Consultee Comment for planning application 23/02399/REM

Application Number	<input type="text" value="23/02399/REM"/>
Location	<input type="text" value="Land North Of Bicester Avenue Garden Centre Oxford Road Bicester"/>
Proposal	<input type="text" value="Reserved Matters approval for 23/01080/OUT - Details of access, appearance, landscaping, layout and scale relating to the proposed development of Class E(g)(i) (formerly B1(a)) office/commercial building and Class E(g)(ii) (formerly B1(b)) Research and Development Units, plus associated car parking"/>
Case Officer	<input type="text" value="Tom Webster"/>
Organisation	<input type="text" value="Clerk to Chesterton PC"/>
Name	<input type="text" value="Jackie Williams"/>
Address	<input type="text" value="Chesterton Community Centre 2 Geminus Road Chesterton Bicester OX26 1BJ"/>
Type of Comment	<input type="text" value="Comment"/>
Type	<input type="text"/>
Comments	<input type="text" value="Chesterton Parish Council agrees with concerns over the pedestrian crossings and access to the site, also of the opinion that the height should not be increased, as it?s very imposing as it is.

PROJECT		BICESTER ARC	
TITLE			
ZONE B		SITE LAYOUT PLAN

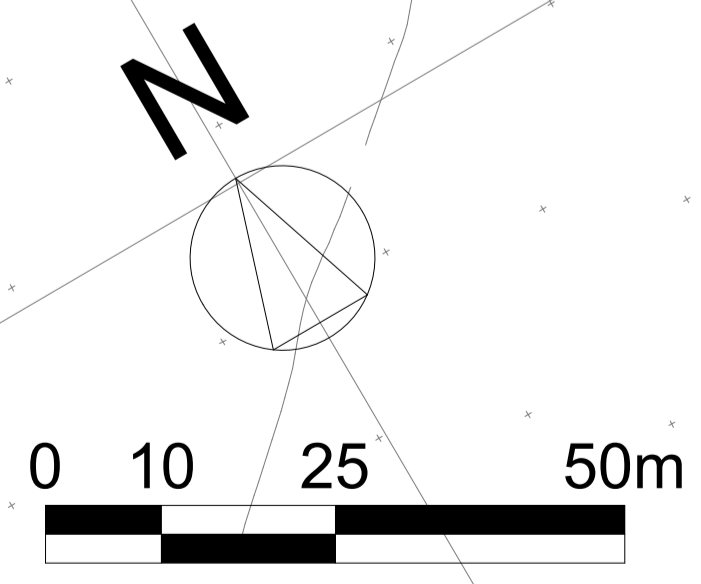
There are concerns over road access from the mini roundabout at the turning into Tesco. Stringent measures will need to be put into place to slow traffic down approaching that roundabout as motorists have used that roundabout in it?s present form for the whole time that Tesco have been open at this site. Drivers are accustomed to traffic joining this already fast paced mini roundabout."/>
Received Date	<input type="text" value="28/01/2024 21:33:27"/>
Attachments
